From: Laura Gibbons
Sent: 10 June 2019 12:58
To: Planning.Responses
Subject: RE: Planning Consultation on WA/99/18/DOC

Engineers comments regarding condition 25& 32- surface water drainage scheme

APPLICATION **WA/99/18/DOC**

Description of Works: Application for approval of details reserved by conditions imposed on planning reference WA/44/17/OUT relating to conditions 5, 9, 10, 11, 12 13, 16, 17, 24, 25, 27, 28, 30, 32, 33, 36, 41 and 43

PRIVATE MANHOLE TYPE A
(DEPTH FROM COVER LEVEL TO SOFFIT OF PIPE 3.0-6.0m)

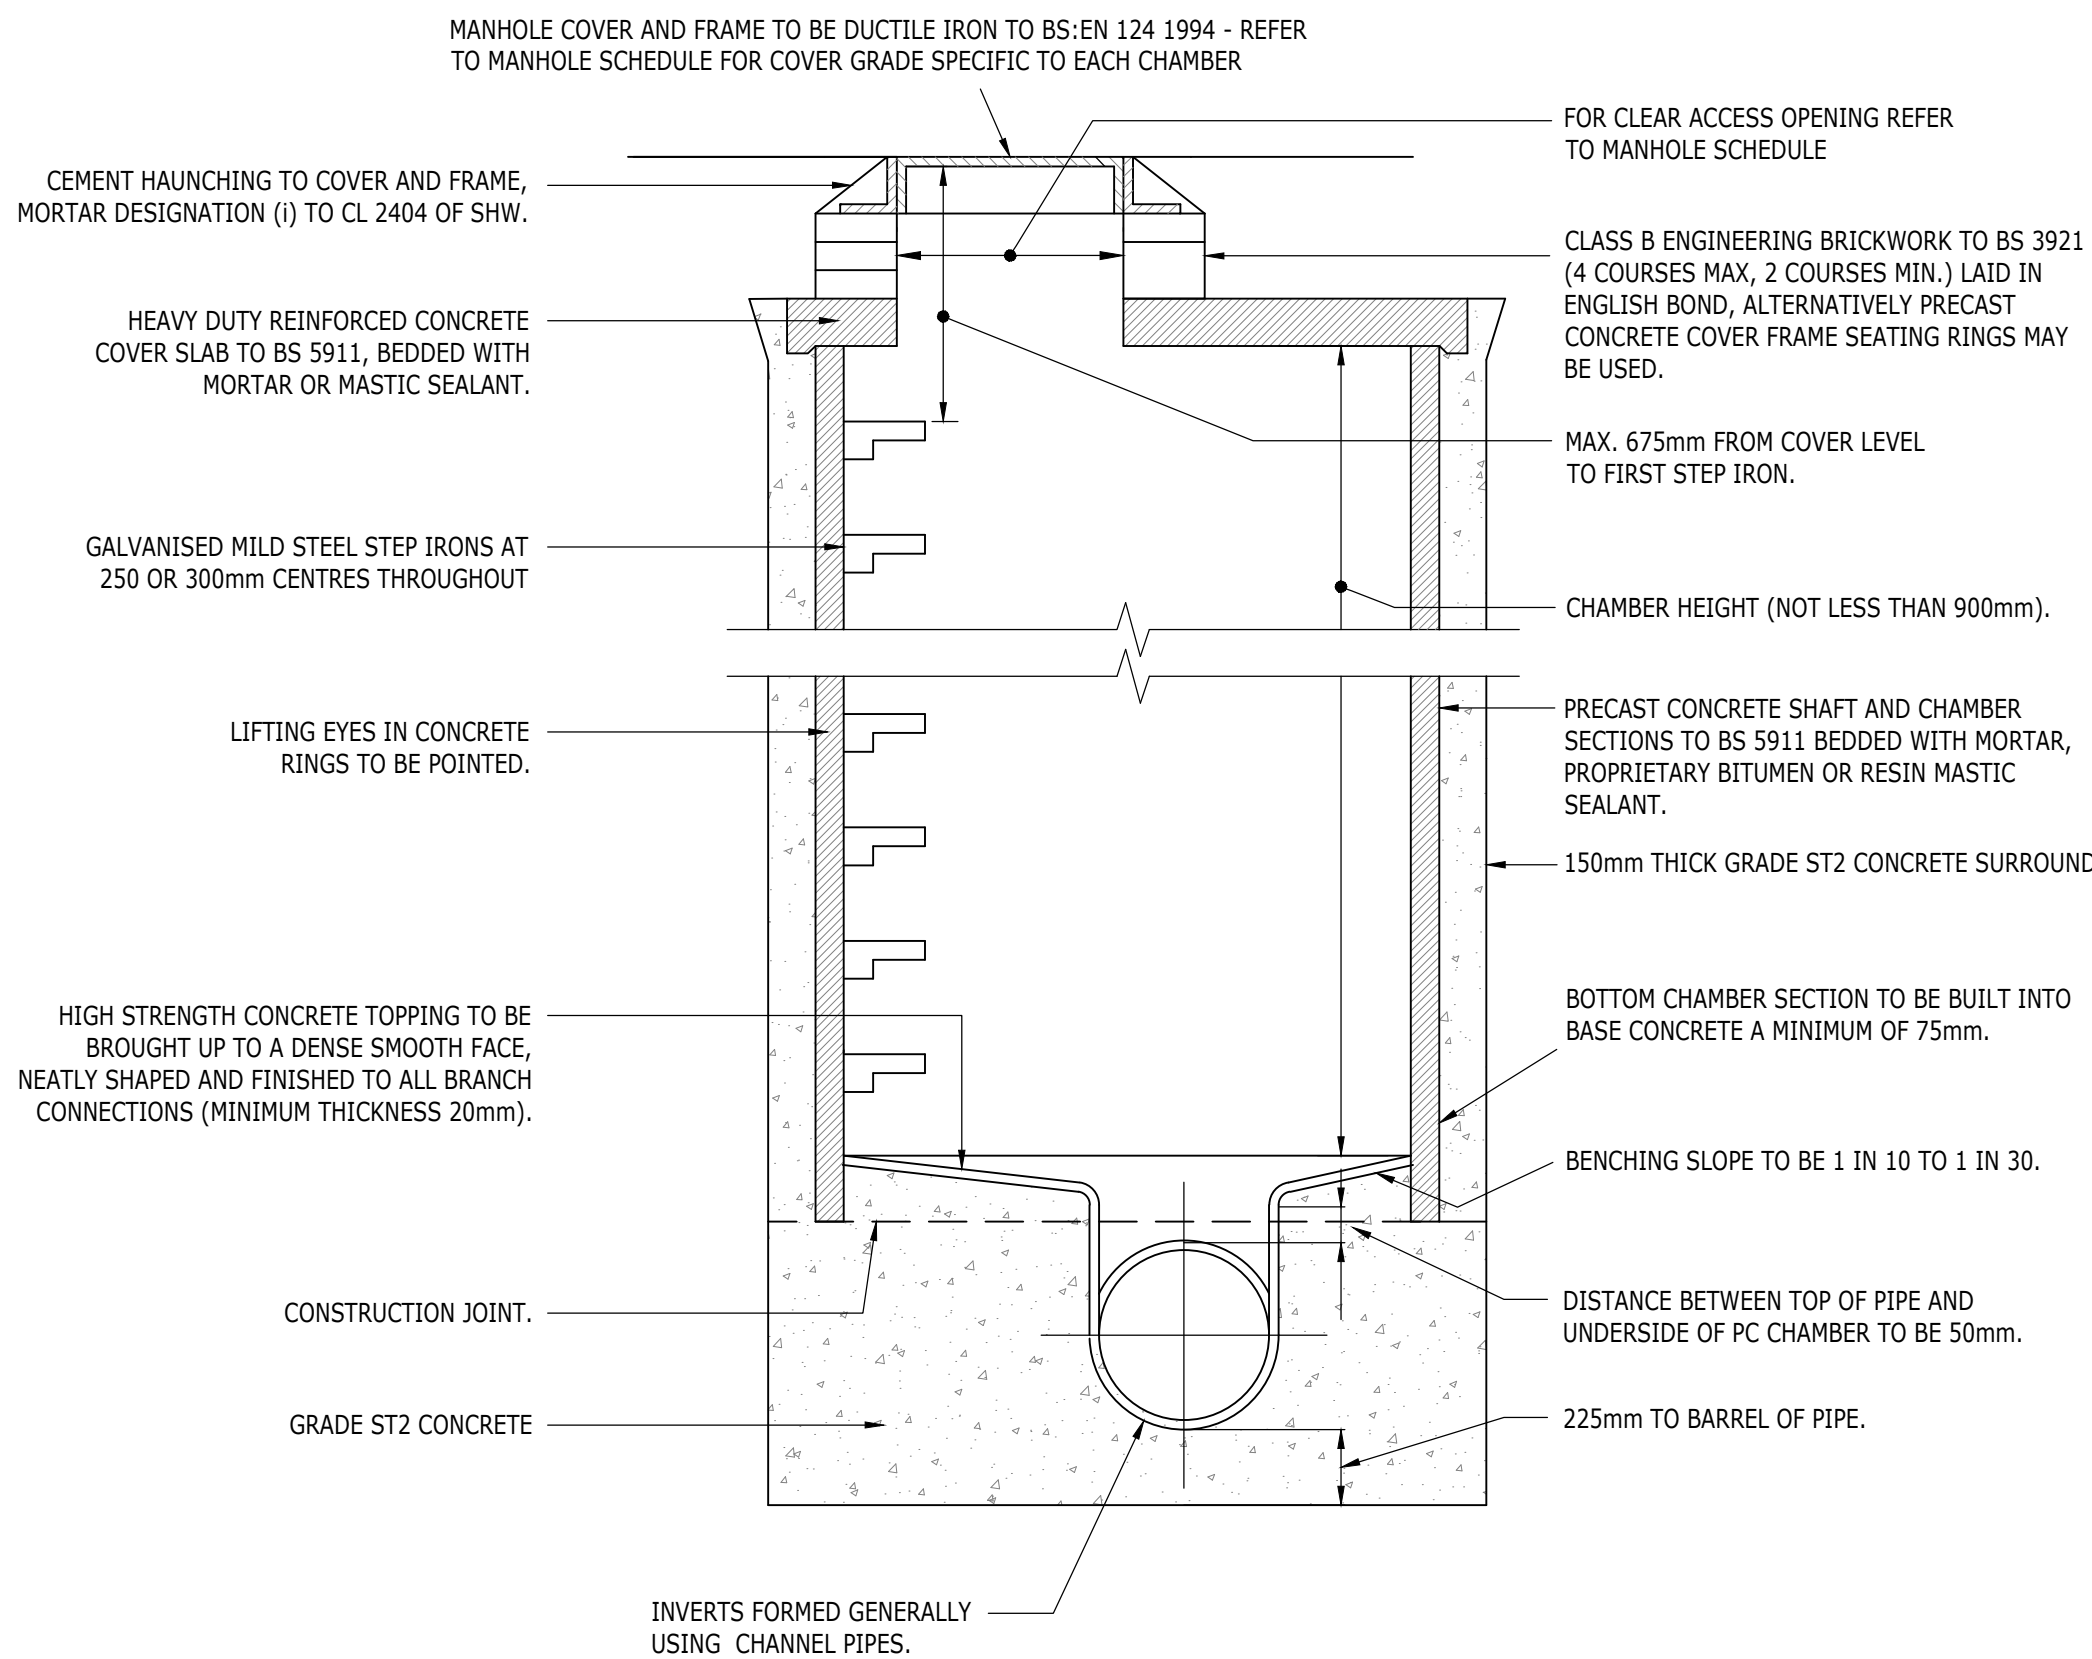
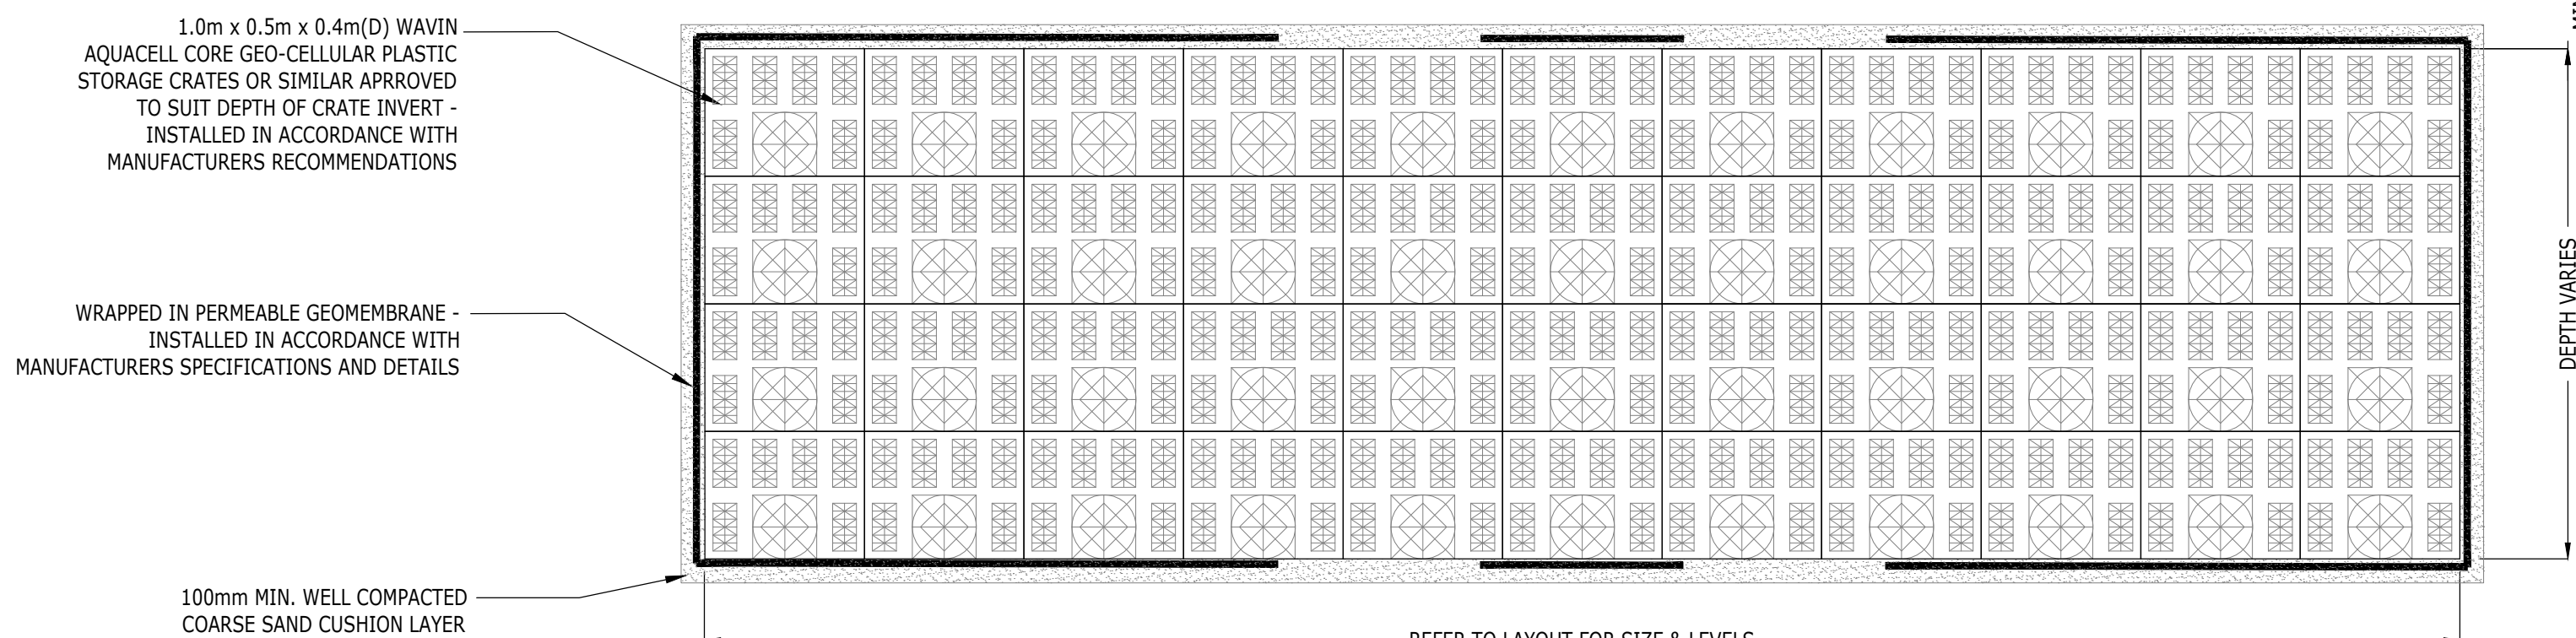
An updated maintenance manual needs to be provided that includes permeable paving, and removes features such as hydrobrakes that are not being proposed for the site.
